<b>Application Ref:</b>	3/2021/0342	 <b>Ribble Valley Borough Council</b> <a href="http://www.ribblevalley.gov.uk">www.ribblevalley.gov.uk</a>
<b>Date Inspected:</b>	22/4/2021	
<b>Officer:</b>	BT	
<b>DELEGATED ITEM FILE REPORT:</b>		<b>Decision</b>   Refusal

<b>Development Description:</b>	Proposed single storey side and rear extension and alterations to existing property.
<b>Site Address/Location:</b>	Holmfield, Long Row, Mellor. BB2 7EF

6169 - P02 REV A

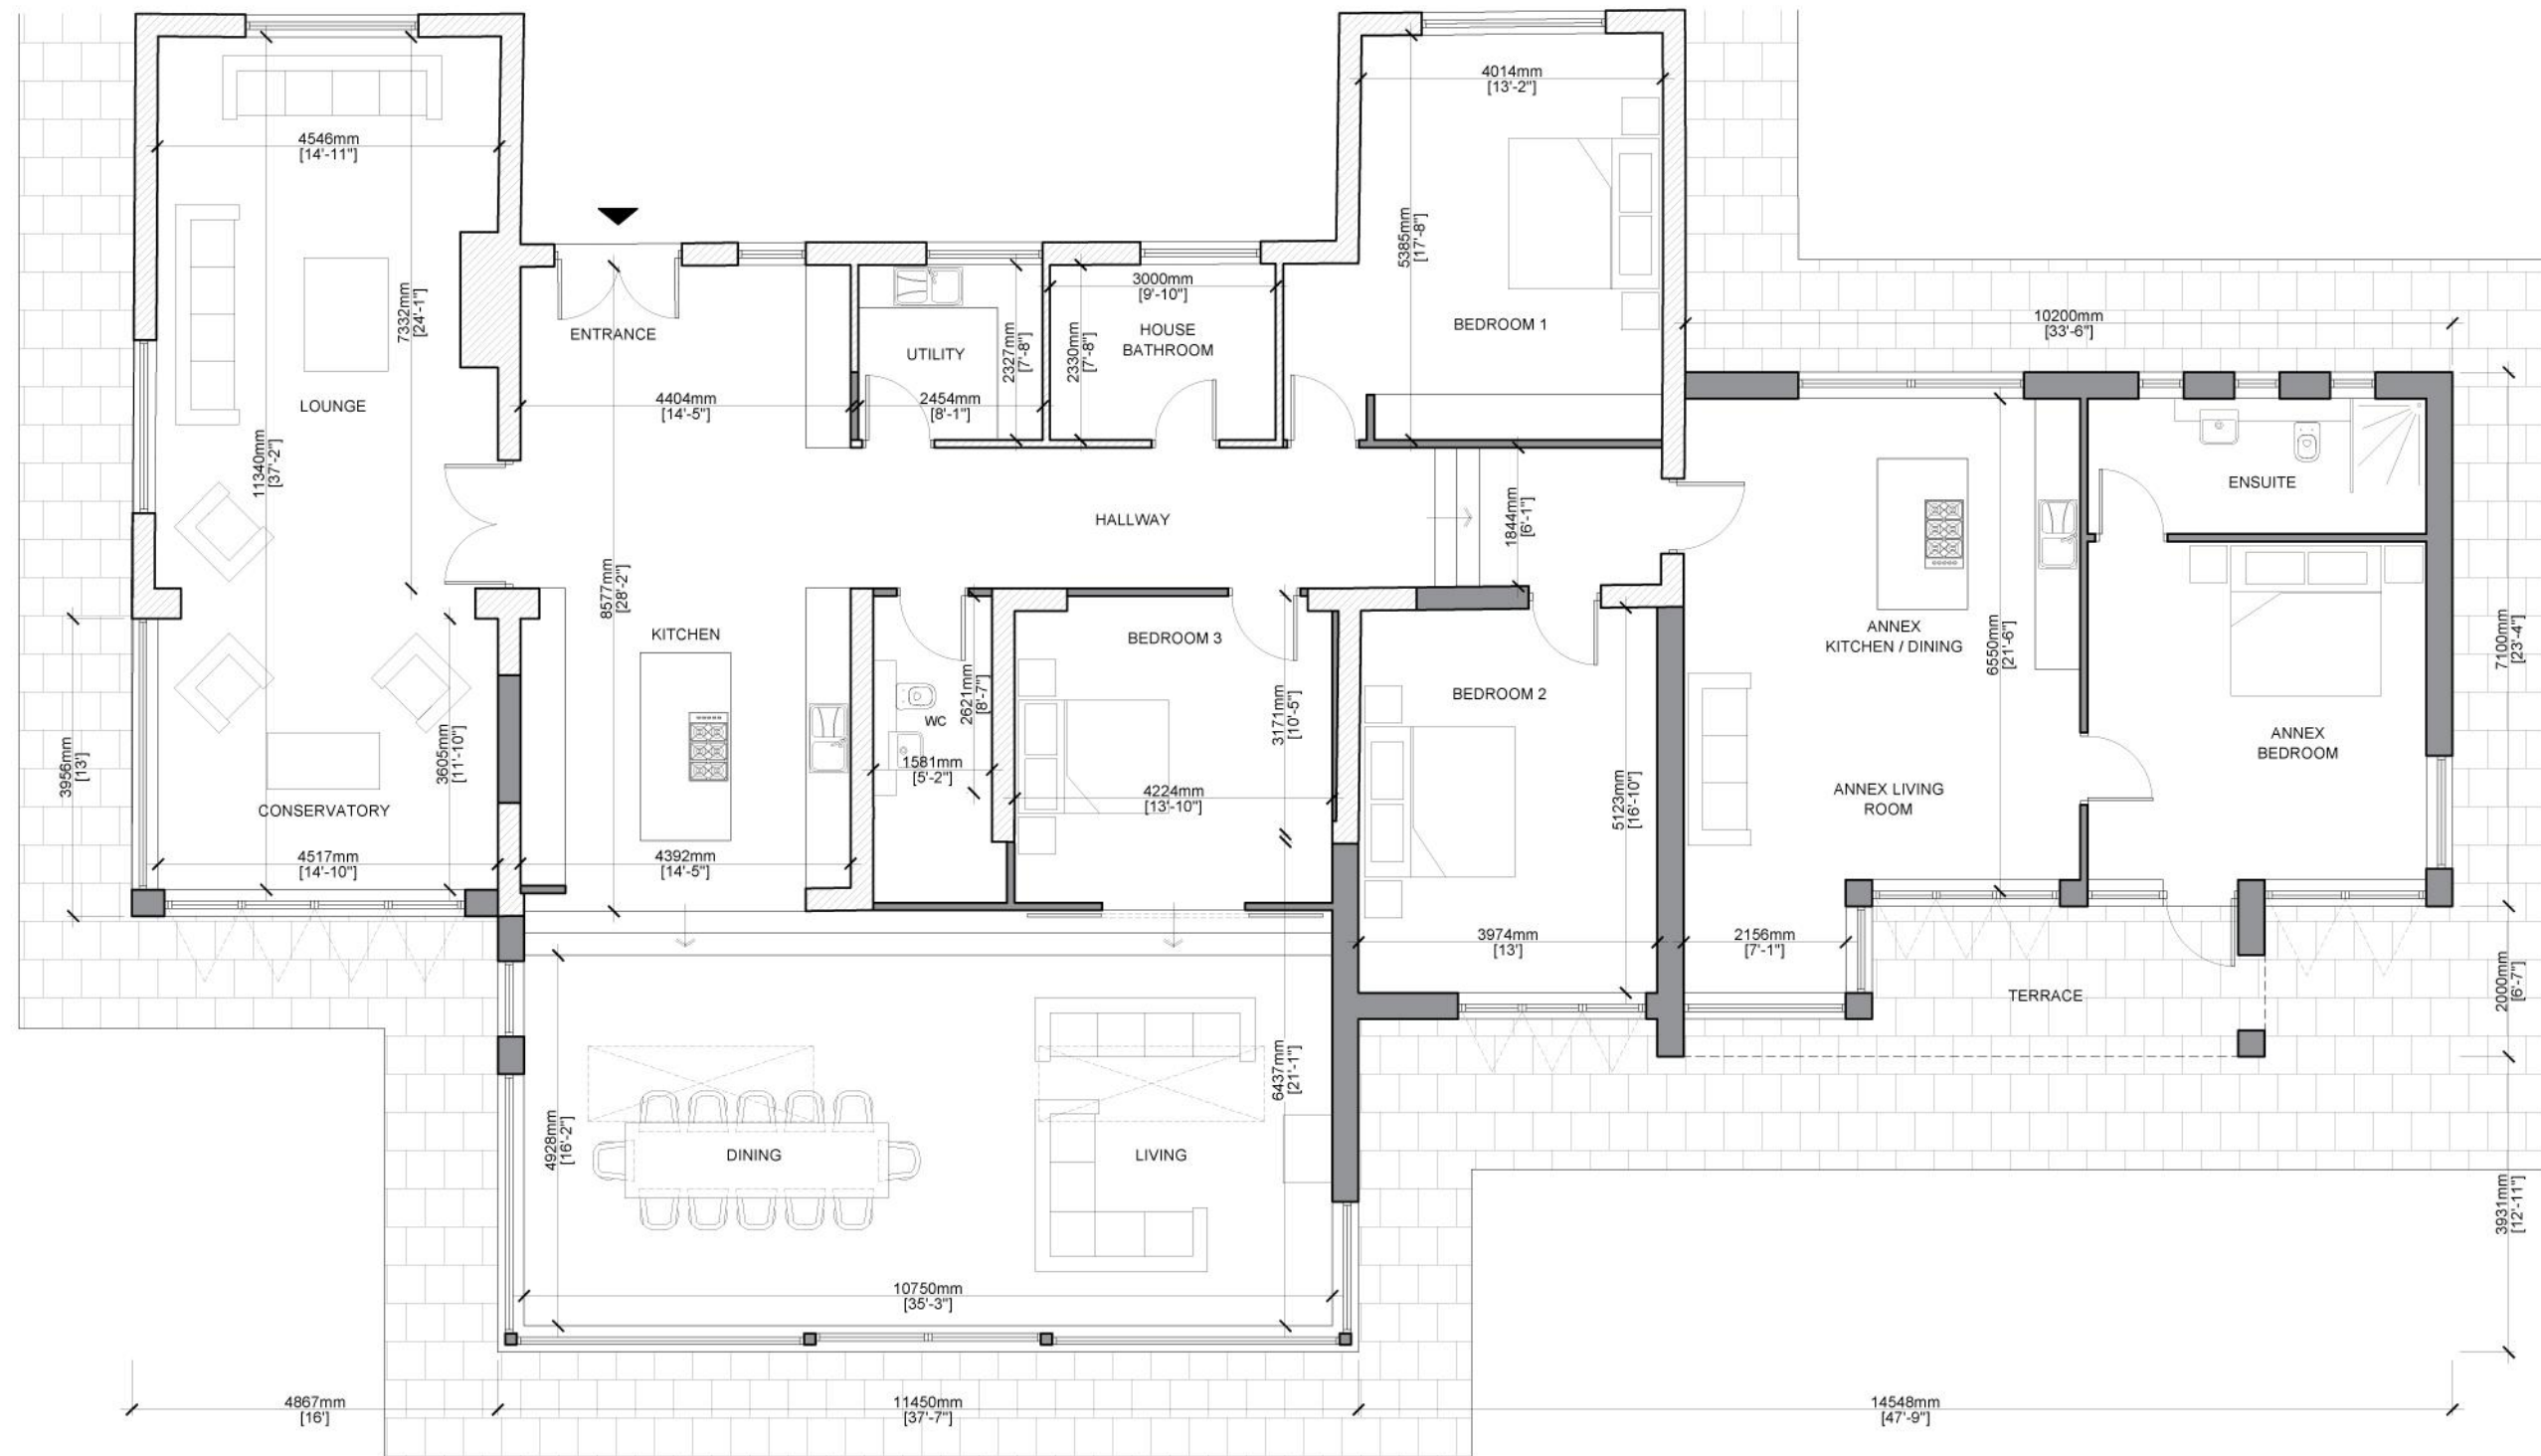
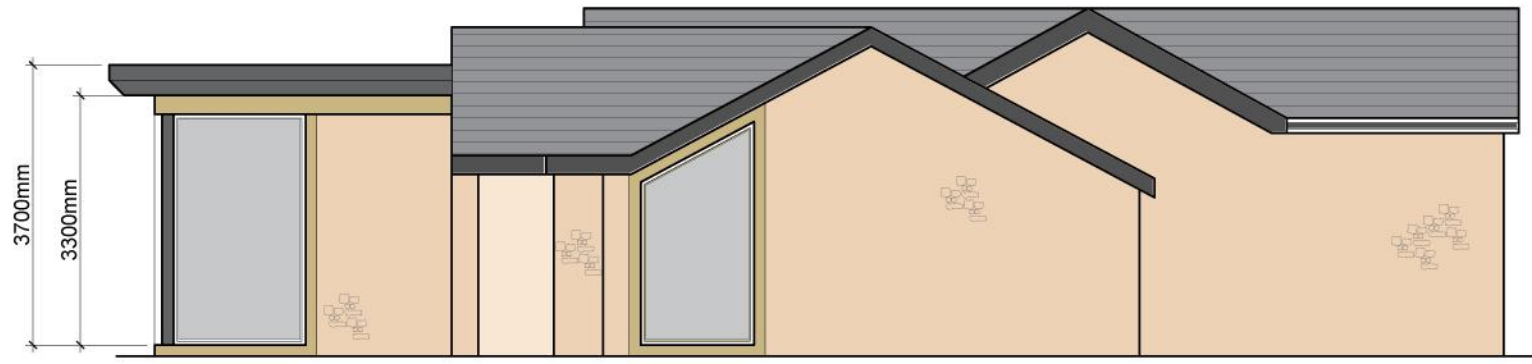
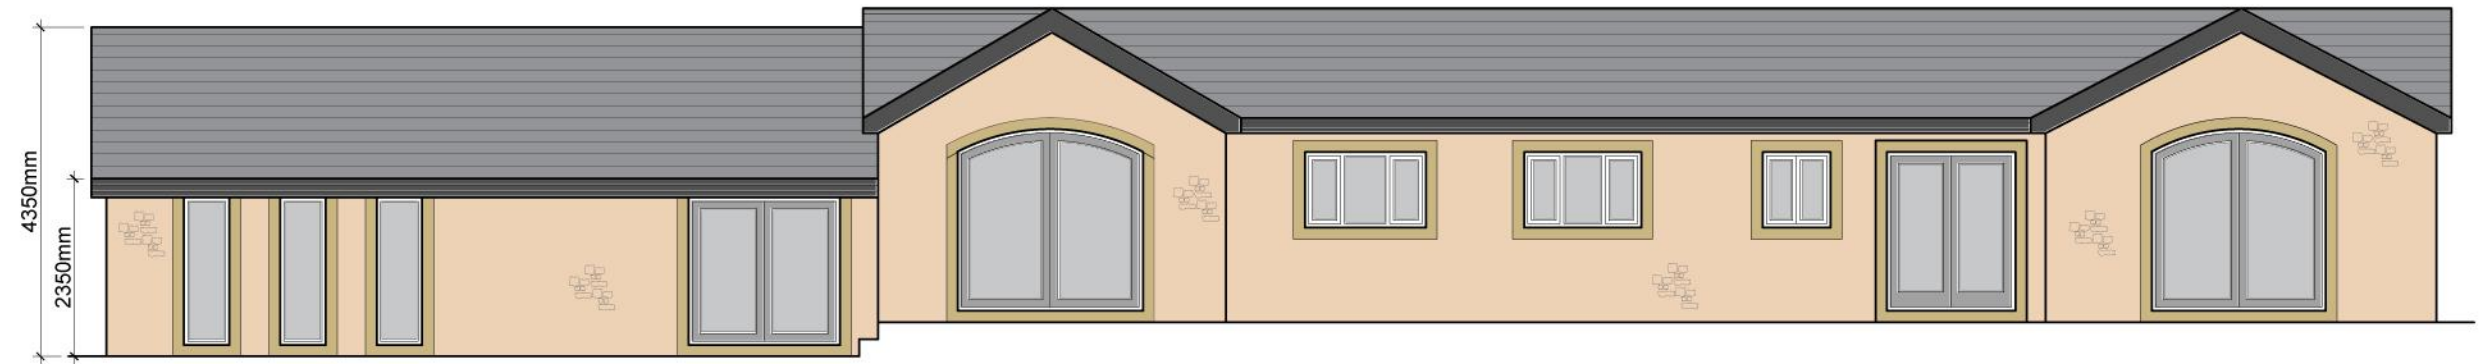
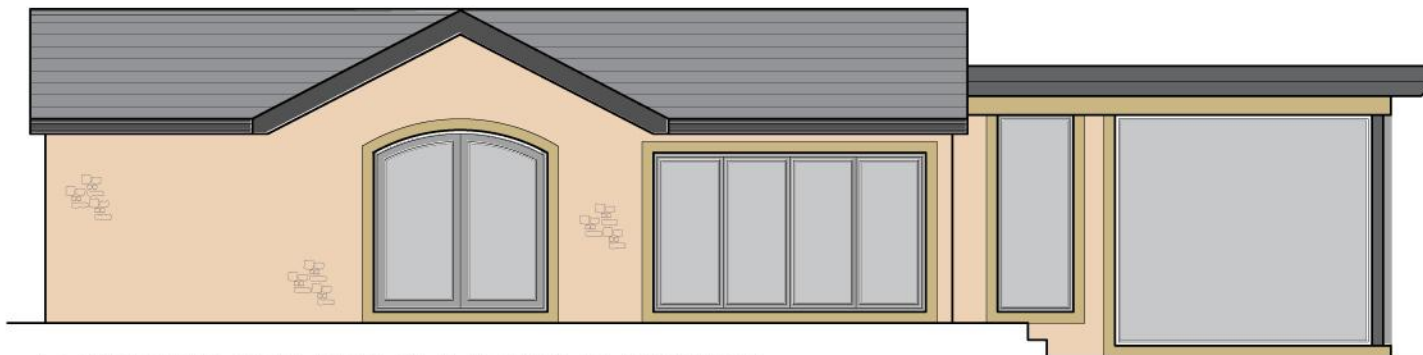
The proposed works comprise a single storey rear extension and single storey side extension which if implemented would almost double the footprint and volume of the original dwelling. Furthermore, the proposed works would be in addition to a previously approved proposal from 2002 which included the addition of a conservatory to the main property and a garage and outbuilding to the property's residential curtilage.

As such, it is considered that the proposed works would be a disproportionate addition to the original property in as much that the cumulative footprint and cubic volume of the previously approved works and current proposal would exceed the footprint and cubic volume of the original dwelling by a considerable measure which in turn would be entirely contrary to the guidance set out in Paragraph 145, part C of the NPPF and Key Statement EN1 of the RVBC Core Strategy.

The proposed rear extension will measure 4.9 x 11.4 metres with an eaves and roof height of 3.3 and 3.7 metres respectively while the proposed side extension will measure 7.1 x 10.2 metres with an eaves and roof height of 2.3 and 4.3 metres respectively.

As such, the proposed works would have some visual impact by virtue of their footprint and extensive use of glazing however both of the extensions would be subservient to the primary dwelling in as much that their eaves and roof pitch height would not exceed those on the main property. Moreover, the extensions would be sited largely out of public view to the side and rear of the property therefore it is not considered that the proposal would have any adverse impact on visual amenity.

The proposed development would result in a disproportionate addition to the original property and is considered to be an inappropriate development in the Green Belt contrary to the provisions of Key Statement EN1 of the Ribble Valley Core Strategy and Section 13 of the National Planning Policy Framework which attaches substantial weight to Green Belt harm. Furthermore, there are no very special circumstances demonstrated which would outweigh this harm.
